33-N-9

2006-0222

297 Cumberland Ave.
Building Addition
Salvation Army

From: Jean Fraser
To: Johnson, Mark
Date: 12/1/2006 4:33:01 PM
Subject: Salvation Army building addition

E5 NORTH ELEVATION

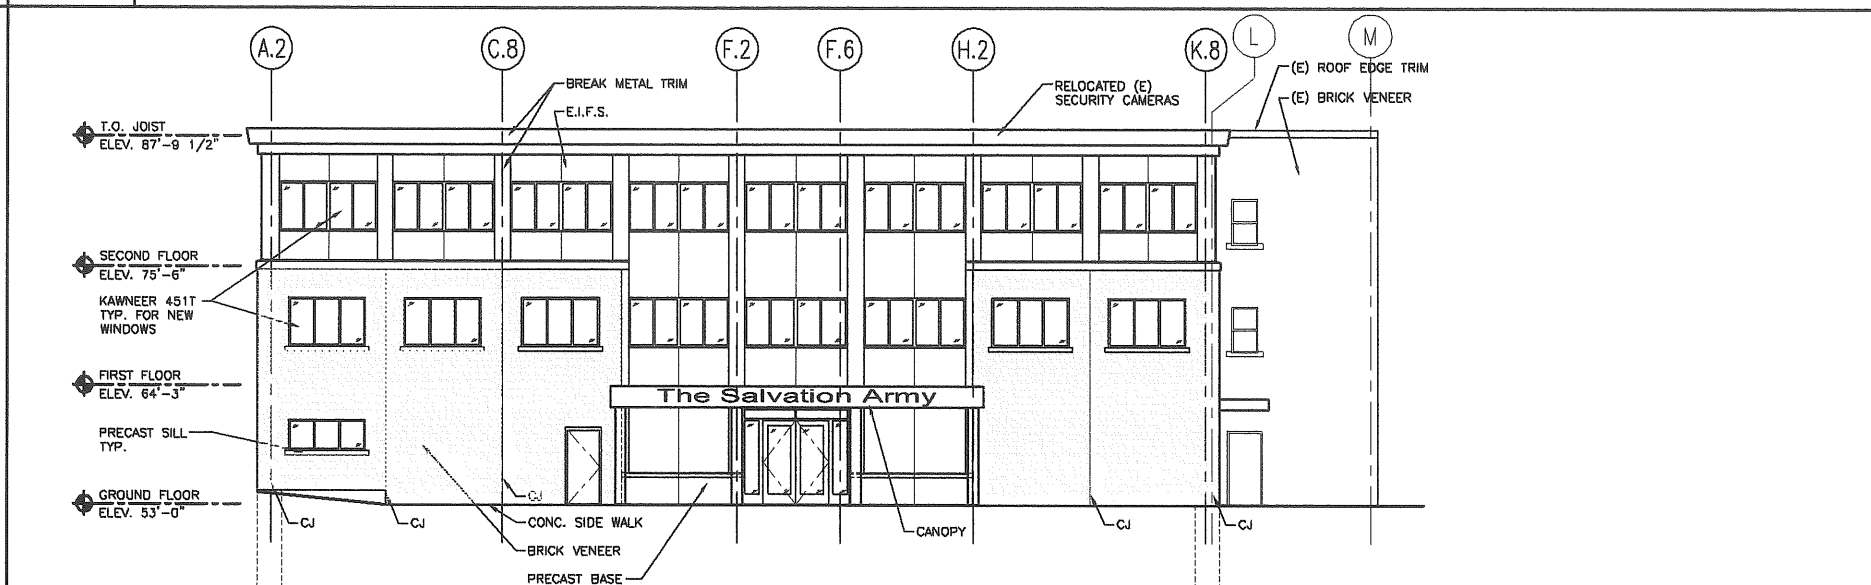
Two exterior wall mounted light fixtures will be located on the north elevation of the building to provide safe and secure illumination of the immediate area (only one was shown in error in the submission). The fixtures will be mounted at a height of 12 to 13 feet, and will be full cut-off. 150 watt high pressure sodium, with a Type IV (forward throw) distribution. The mounting height combined with the distribution and cut-off characteristics will result in significant glare reduction over the four existing wall packs being replaced. Recessed "can" fixtures will be located in the new door canopy providing focused illumination at the entry.

SHEET TITLE:  
 EXISTING CONDITIONS  
 SHEET No. CP101

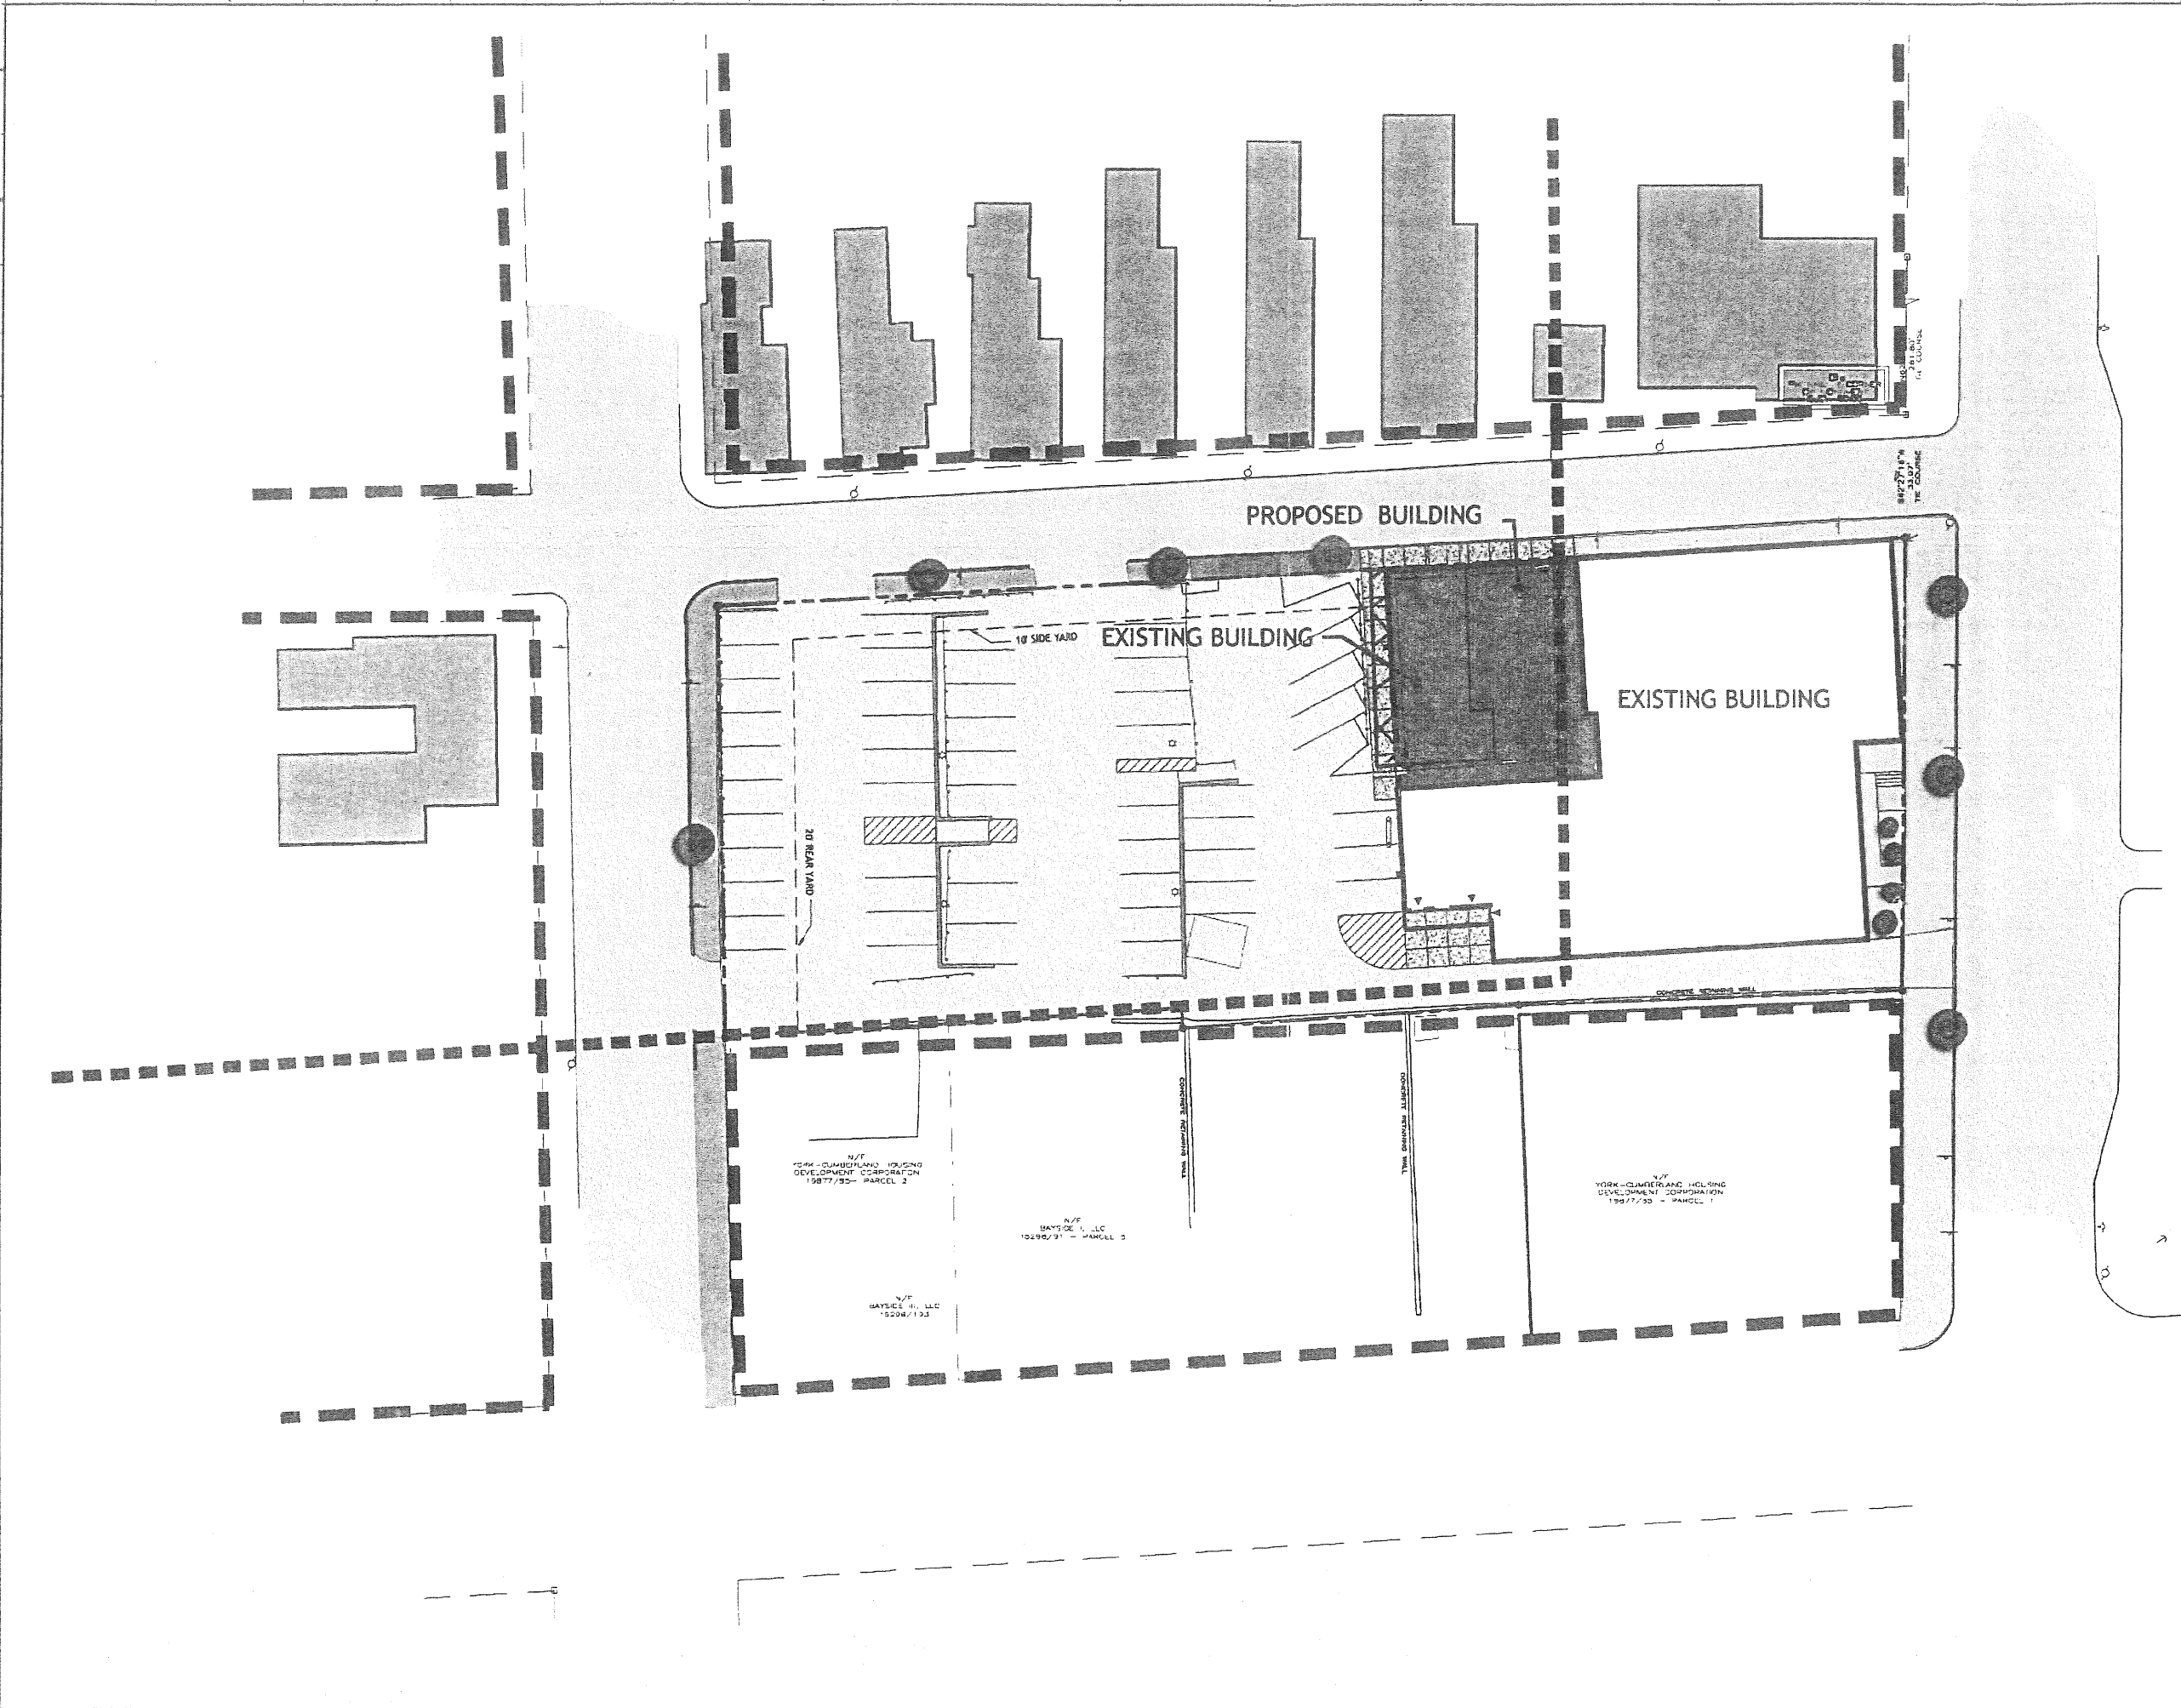
Regarding the zoning lines that you overlaid on the Layout Plan, how did you arrive at those? The reason I ask is that Rick Knowland and I reviewed the zoning and height overlay plans in relation to this site and thought that the B3 line was just at the back of the existing SA building along Cedar Street (ie that the building addition was totally within R-6). So could you clarify on that please.
